REAL ESTATE ASSESSMENT RECORD - CITY OF PORTLAND, MAINE

Permit No: 05-1006	Issue Date: NOV 3 2005	CE#: 040 AC24001
-----------------------	---------------------------	------------------

Proposed Project Description:
 build 14' dormer on 3rd floor of a three unit apartment building
15' shown on drawings

1" = 12'-8"

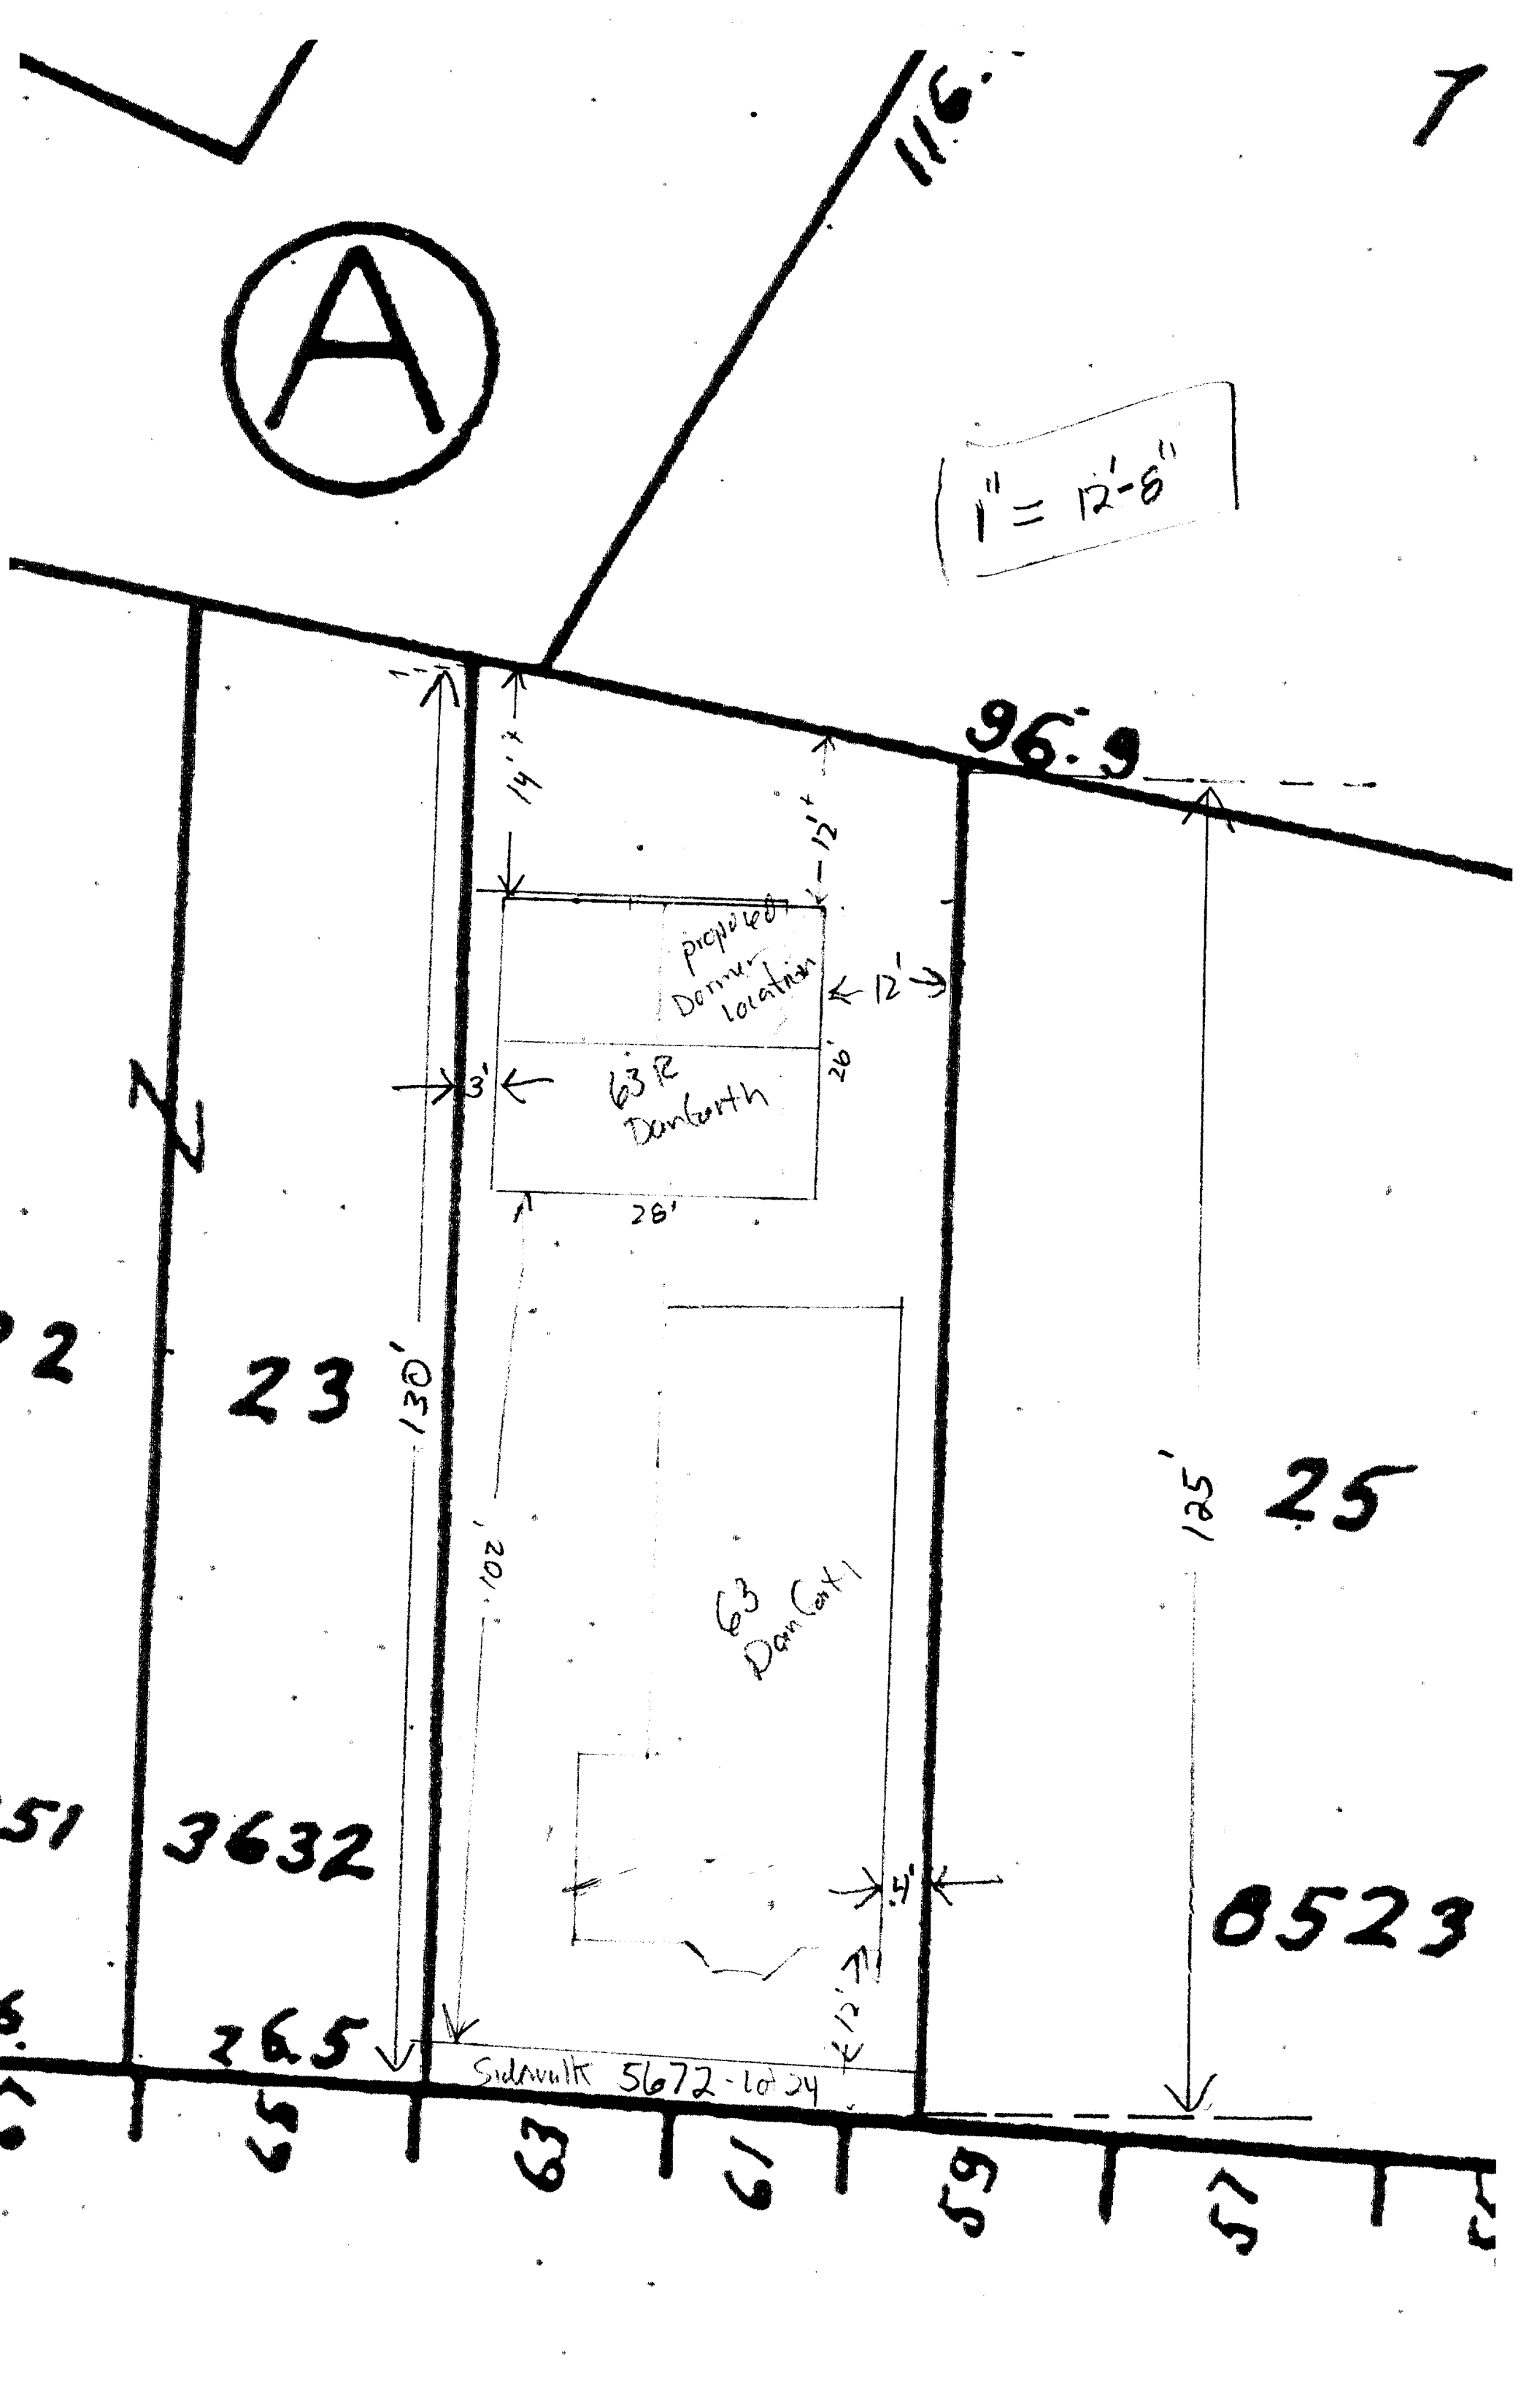
- 1) All building construction to comply with Nfpa 101
Insure two rated means of egress.

10/31/2005-mjn: Left message w/ Builder regarding current configuration of the space, egress etc.

11/02/2005-jmb: Spoke w/Nathan H. About existing use & egress; kitchen/bath in a sloped ceiling. Will change rafters to 2x10, insulation per code. No tub/shower on window wall. Ok to issue

63 rear 3<sup>rd</sup> Floor

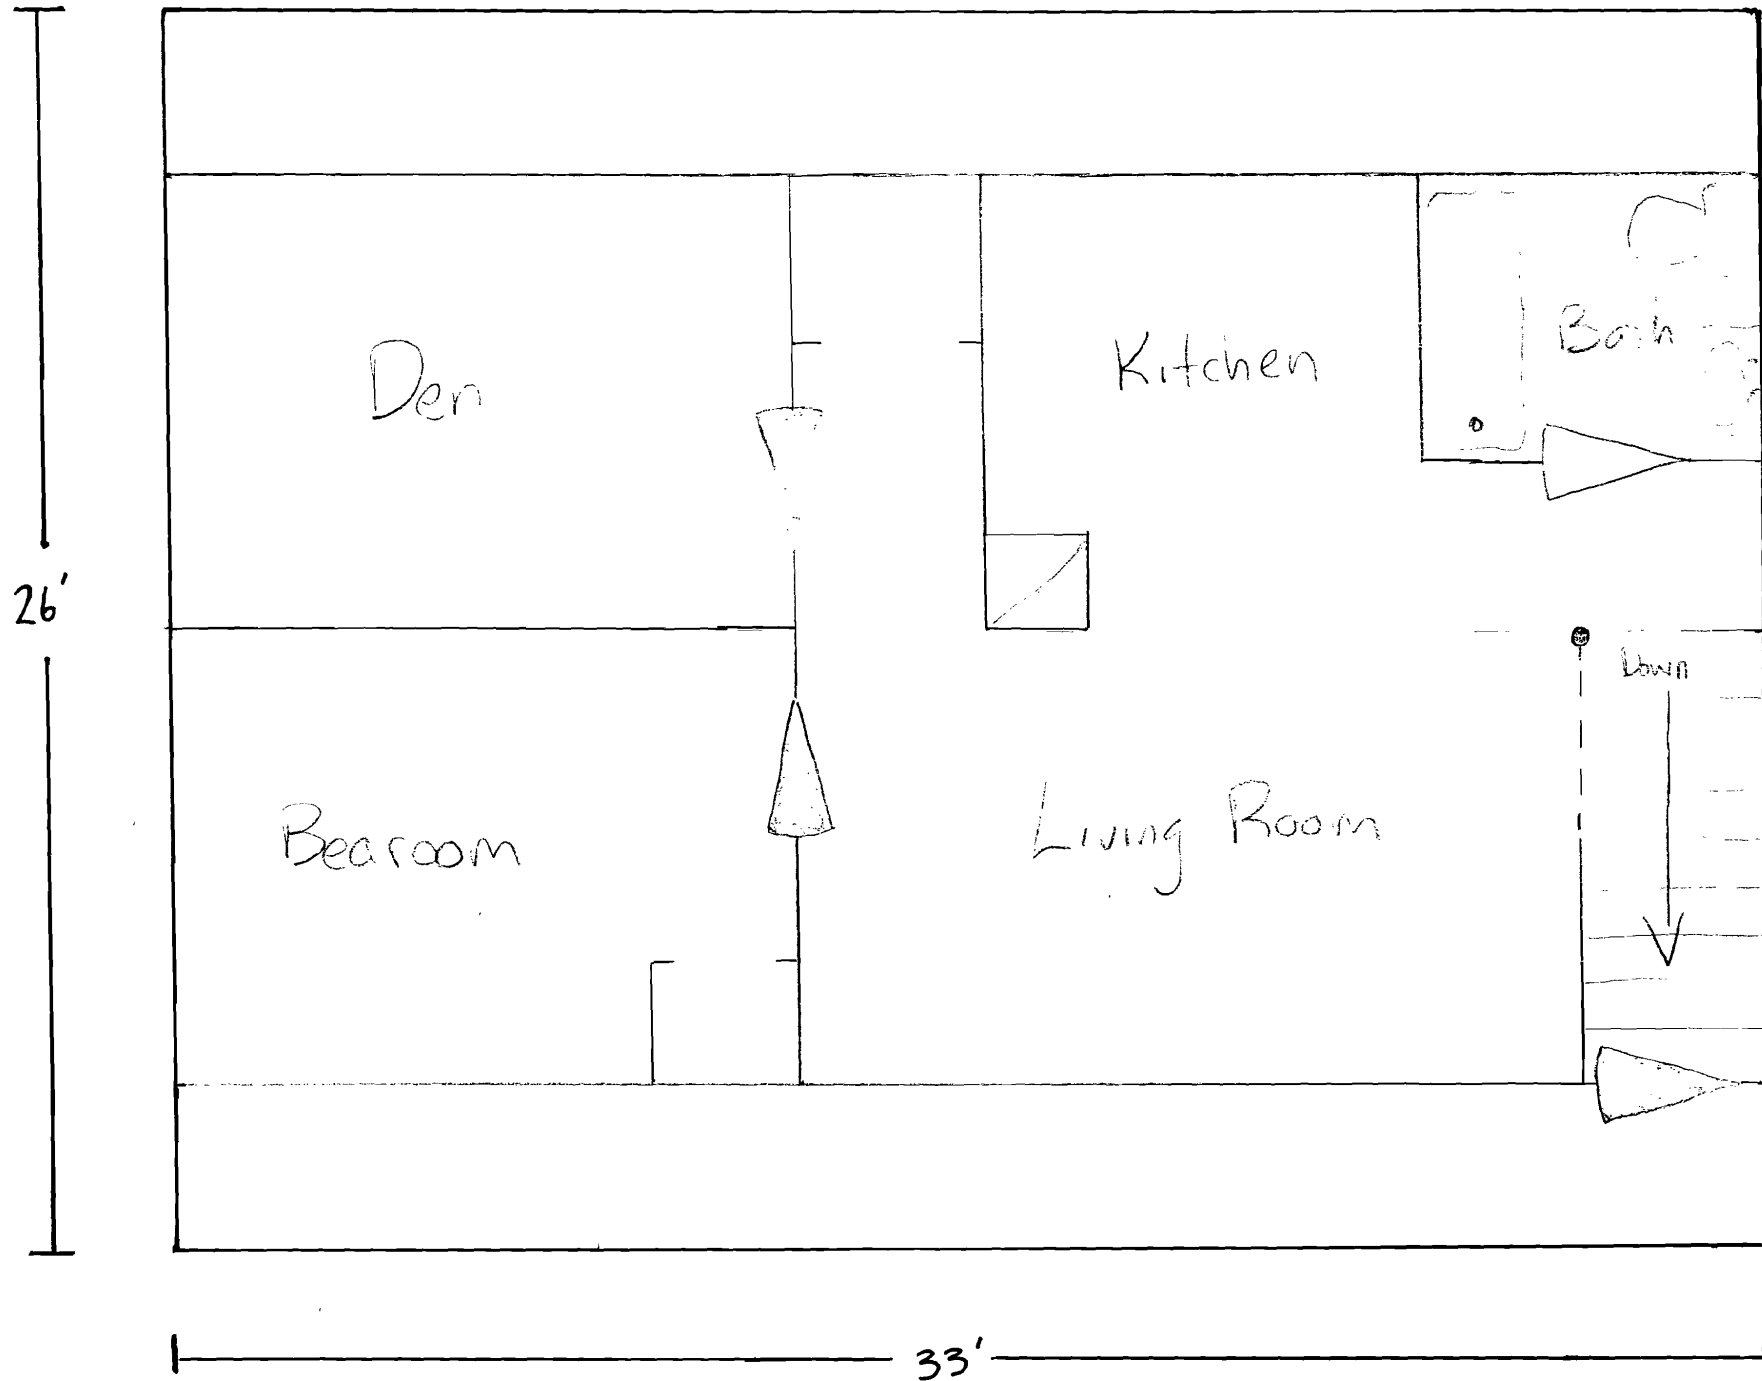
- 1) The allowance for this expansion is based upon section 14-436 which states that if the property is legally nonconforming as to lot size and setbacks, you are allowed to expand upward not more than 50% of the first floor footprint. Your current request for a dormer uses 27% of the allowable 50%. The 50% expansion is allowed only once during the life time of the building.
